March 7, 2024 PLANNING COMMISSION
FOREST HEIGHTS ESTATES MS206
Adjacent Landowner (since 1969) Parcel 108

REQUEST: Please include the option to place the cul de sac required by ECM further west between Lots 1 and 4 and allow private driveways to access Lots 081 and 108 east of the cul de sac.

FOREST HEIGHTS CIRCLE
CONSTRUCTION DRAWINGS
PLAN AND PROFILE
13+50 TO 23+75

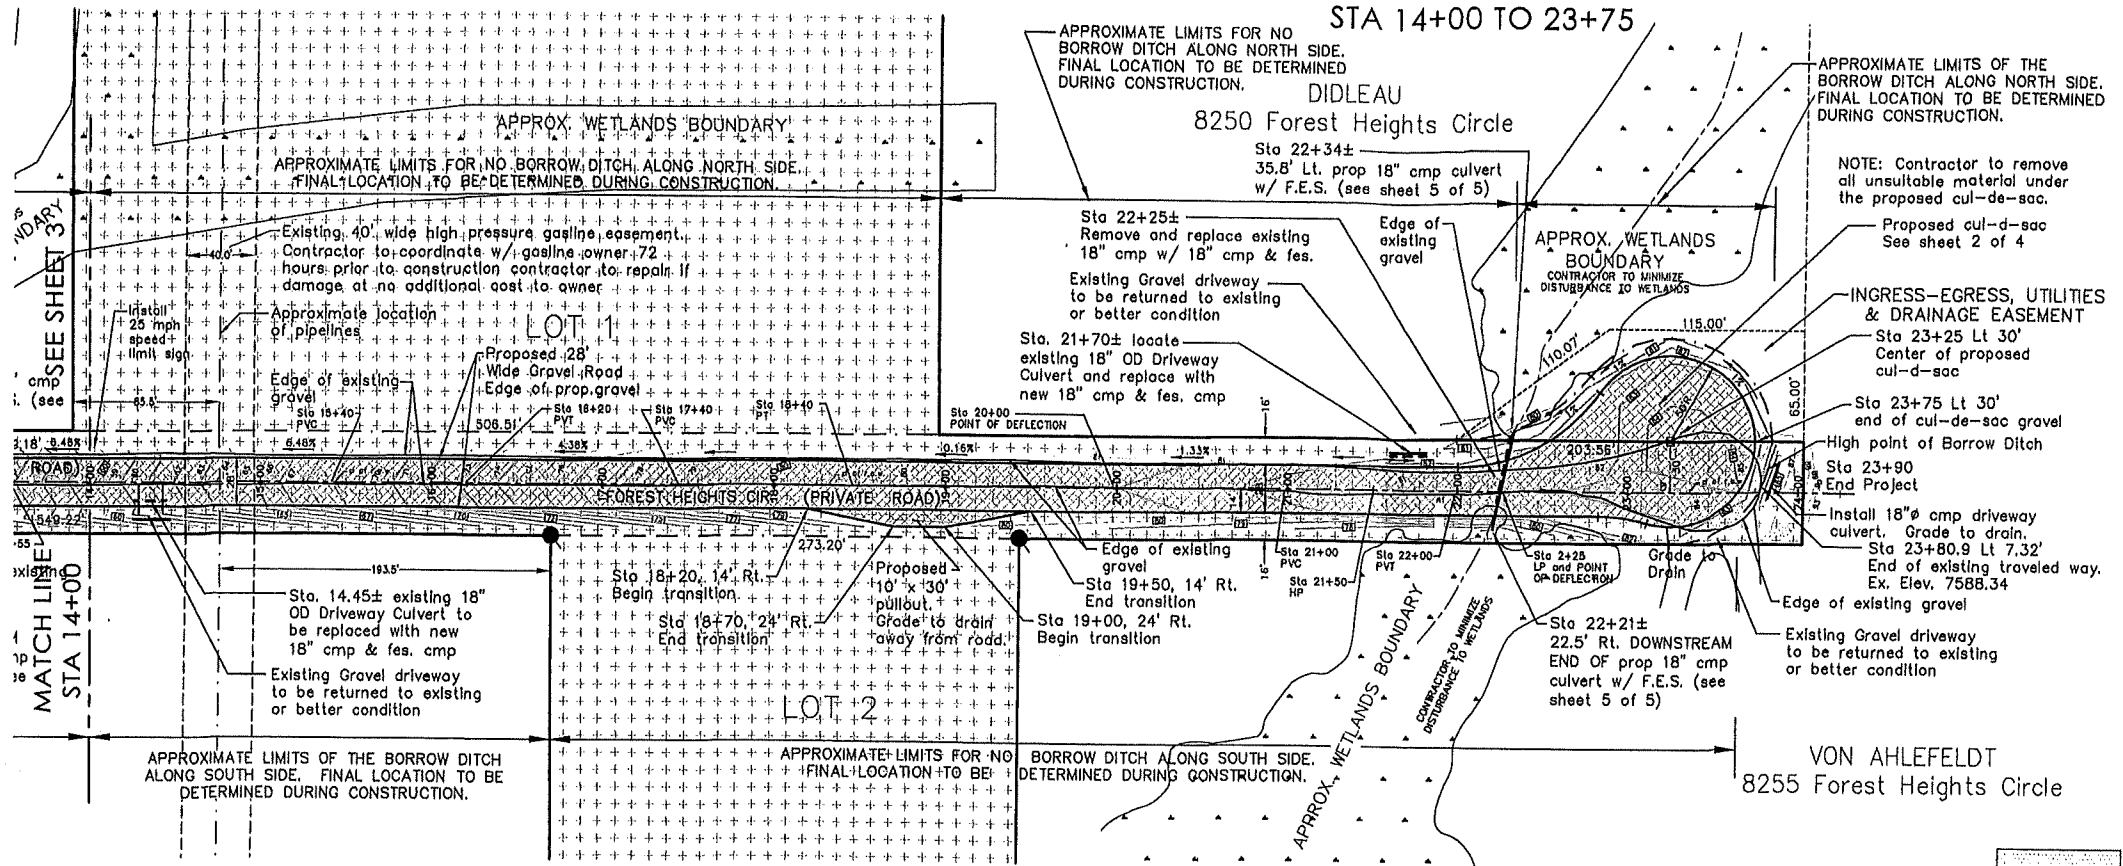
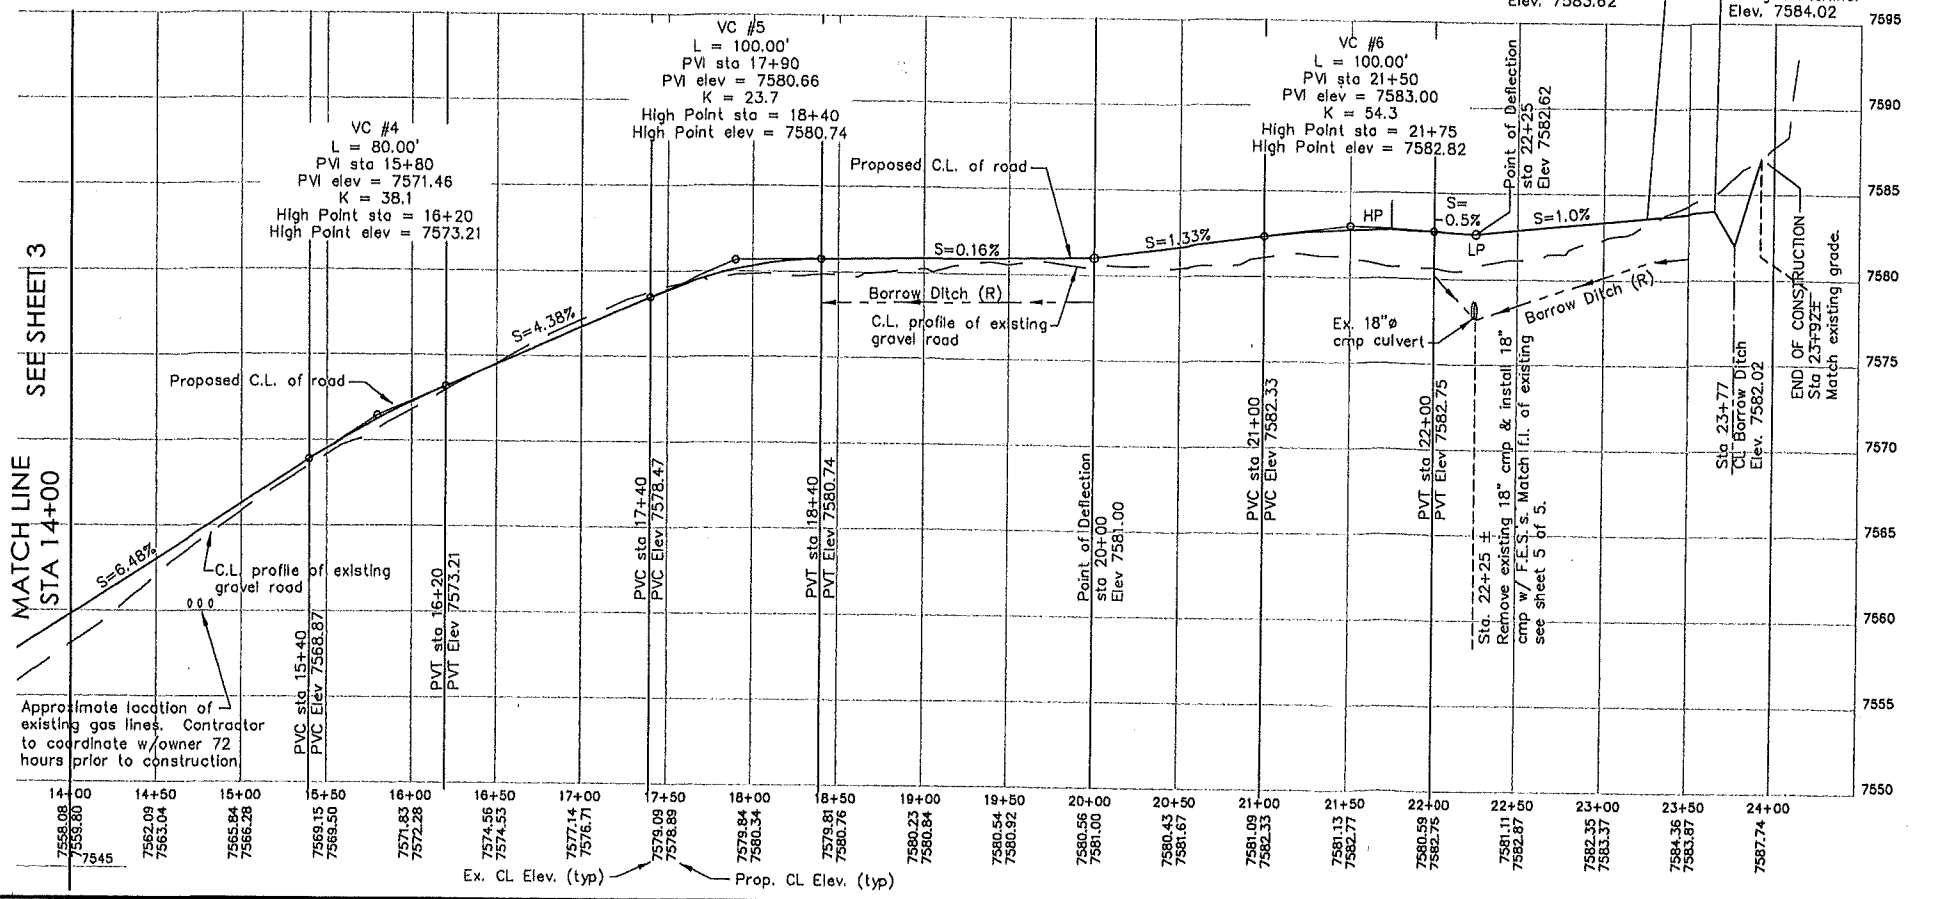
- Positioning of cul de sac east of lots

Two private driveways would service two existing lots impacts wetland, gas line and electric/ phone lines. Road could be widened to Lot 081 drive way & existing culvert extended.

- Positioning the new-built cul de sac at the turn -around at east end of "road", between two lots not in the subdivided new lot area causes impact to existing gas and phone lines, unnecessary (serviceable culvert) replacement, removal of mature trees on private land to north, unnecessary construction impacts to stable landscape, and causes extra hardscape disrupting native Burgess River wetland.

- The existing turn-around is 85 feet wide and the driveway to Lot 108 on the south adds additional width.

- **STRONG OBJECTION** to submittal's positioning of the cul sac:
 - it is the most expensive option for the Developers,
 - most intrusive placement for Existing Lot owners,
 - should be placed between New Lots, not existing Lots
 - highest impact on a stable and recovering landscape, a wetland and existing utilities which are in the way of an aggressive and unnecessary road reconstruction plan for the east 406 feet of the road crossing Burgess river and on my north property line.
